CDS is requesting comments on the following Accessory Dwelling Unit application: AU-26-00007 Hill.

TO: All Staff
FROM: Public Works Plan Review Team
DATE: June 1, 2026
SUBJECT: AU-26-00007 Hill

SITE PLAN  
 SCALE 1" = 50'-0"  
 0' 50' 100' 150'

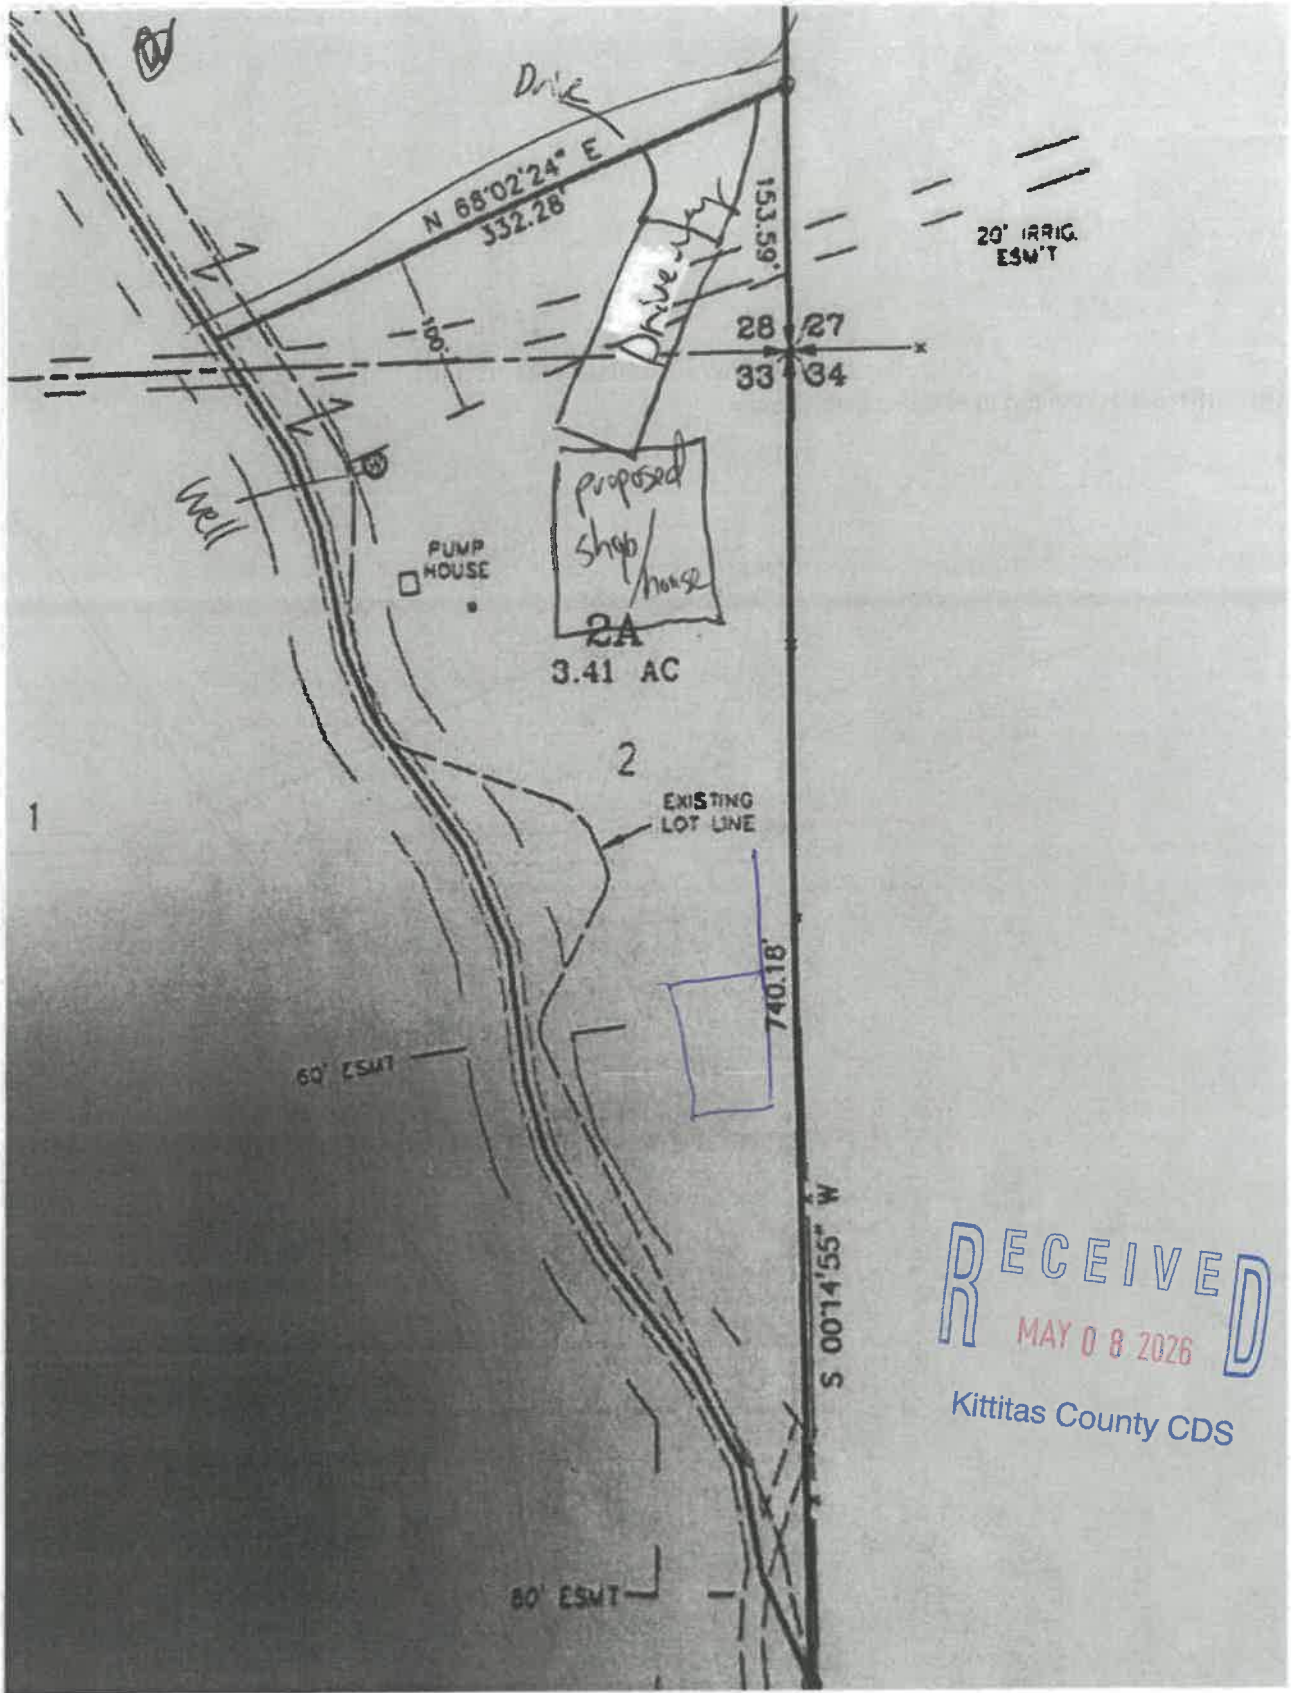
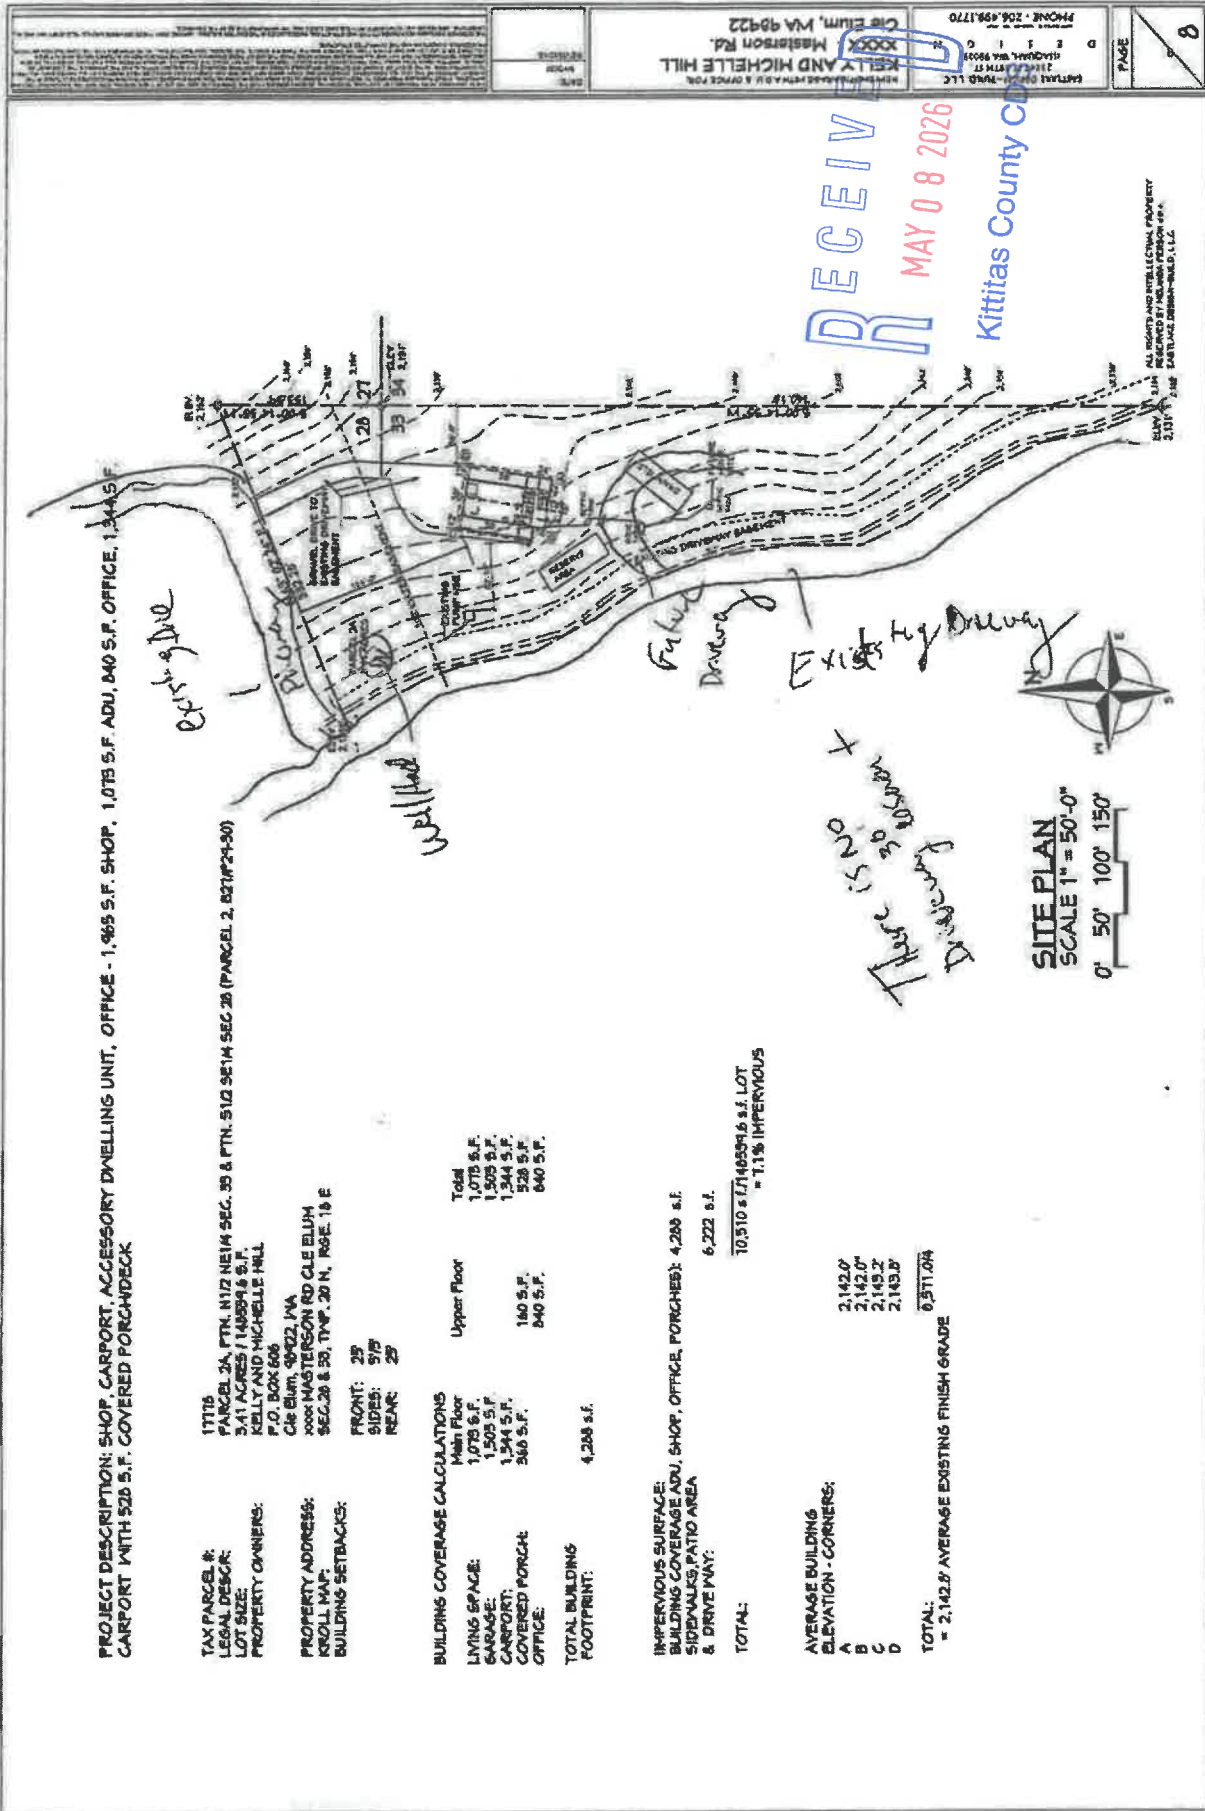
SURVEY	<p>CDS considers the nearest lot line to the proposed ADU as a rear yard. Due to the proposed building being on this setback line, the building envelope should be staked out by a surveyor licensed in the State of Washington to prevent the possibility of encroaching into the setback area. (JT)</p>
TRANSPORTATION CONCURRENCY	<p>Not applicable to this project as proposed. (RC)</p>
FLOOD	<p>Parcel #17778 is not mapped within a FEMA identified special flood hazard area (1% annual chance flood zone). A floodplain development permit is not required for the proposed ADU. (SC)</p>
WATER MITIGATION/ METERING	<p>The proposed ADU requires water mitigation and metering per KCC 13.35.027 since it is a new use of groundwater. Public Works has issued a water mitigation certificate for the project, WM-26-00027. The water meter must be installed and inspected prior to building final. (SC)</p>

Driveway must meet county code for length and width per KCC 12.04.07.060 #12 and meet International Fire Code Appendix D.
